## OFFICIAL NOTIFICATION OF DECISION

**Project# PR-2018-001198**

**SI-2021-00383 SITE PLAN**

For all or a portion of: **TRACT 11 (FORMERLY TRACT 1), CATALONIA (THE TRAILS)** zoned R-ML, located on **WOODMONT AVE NW** between **PASEO DEL NORTE** and **GIRONA AVE NW**, containing approximately 13.9 acre(s). (C-8)

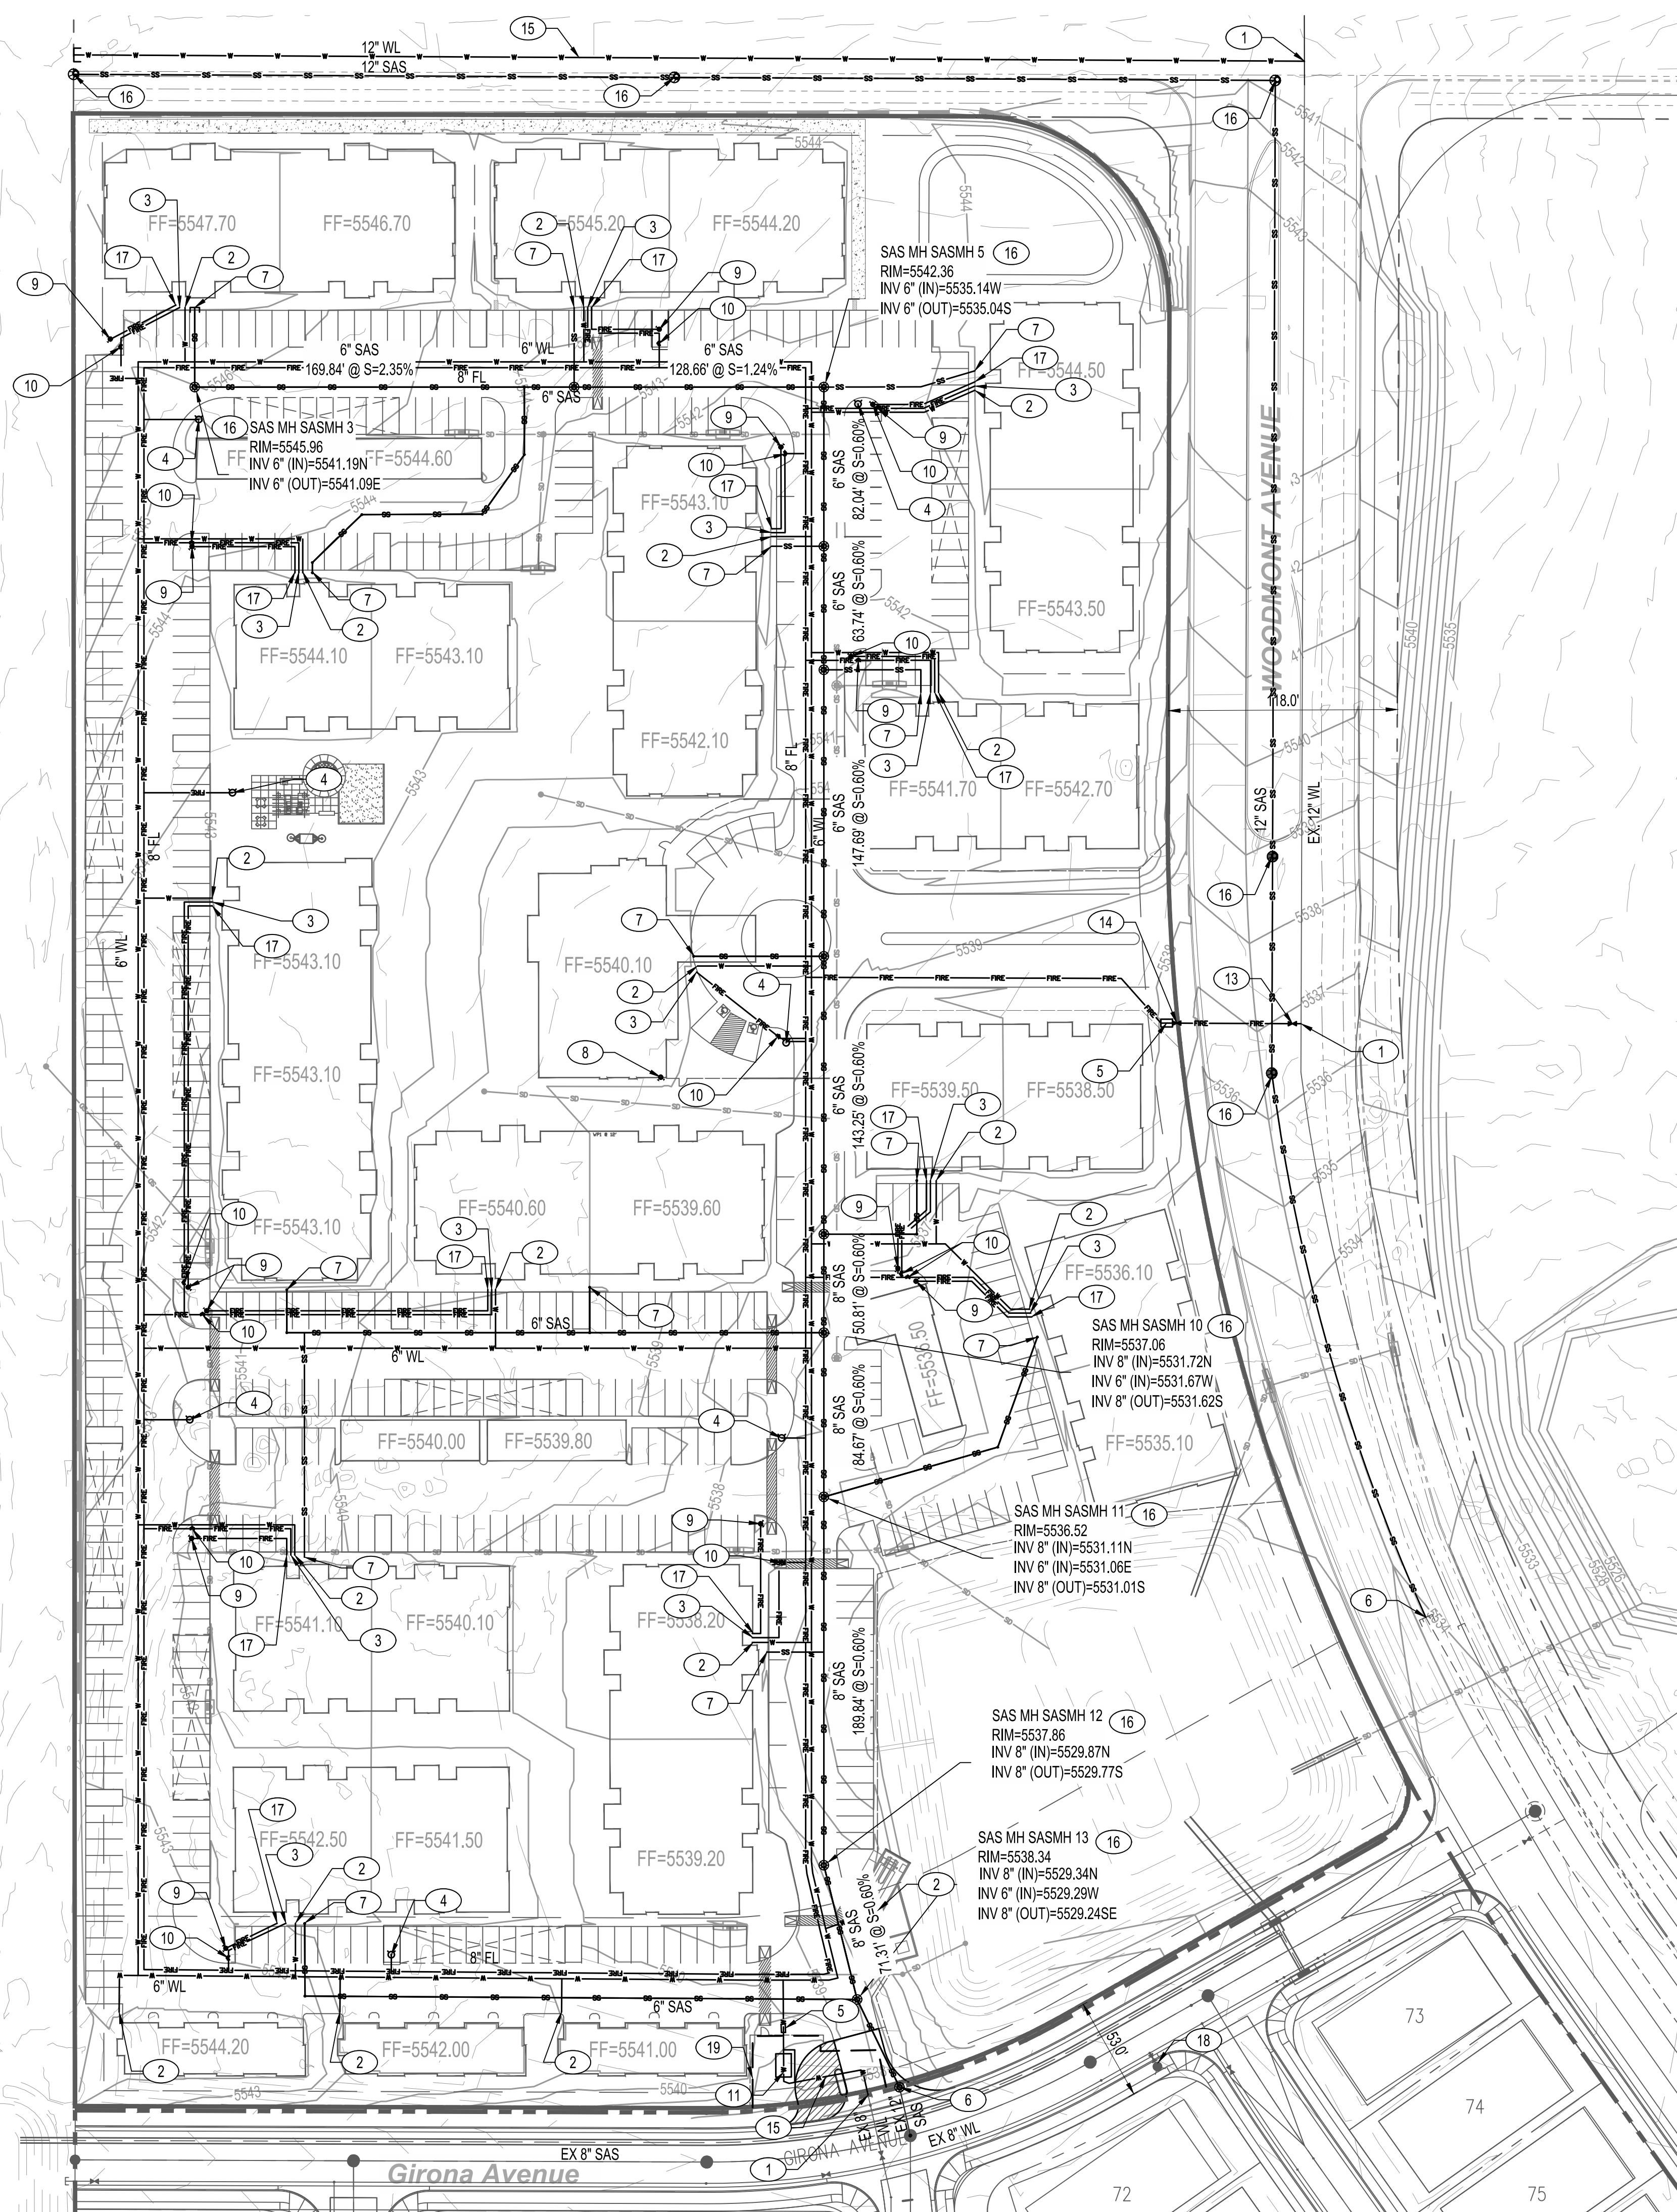
1. This Site Plan is valid 7 years from DRB approval (5/19/2021). An extension may be requested prior to the expiration date.
2. Final sign off is delegated to Transportation to use correct clear sight triangles and to modify landscaping as necessary, to show all vehicular and pedestrian accessway widths, to call out correct pedestrian ramp configurations, and to reference detail on handicapped spaces with a keyed note on the plan and to specify types of curb ramps with keyed notes on the plan.

3. Final sign off is delegated to Planning for the Solid Waste signature, the recorded IIA, and to add notes on the site plan outlining the methods that will be used for final stabilization of Ponds "A" and "C" with native grasses/wildflowers.
4. The applicant will obtain final sign off from Transportation and Planning by August 19, 2021 or the case may be scheduled for the next DRB hearing and could be denied her the DRB Rules of Procedure.
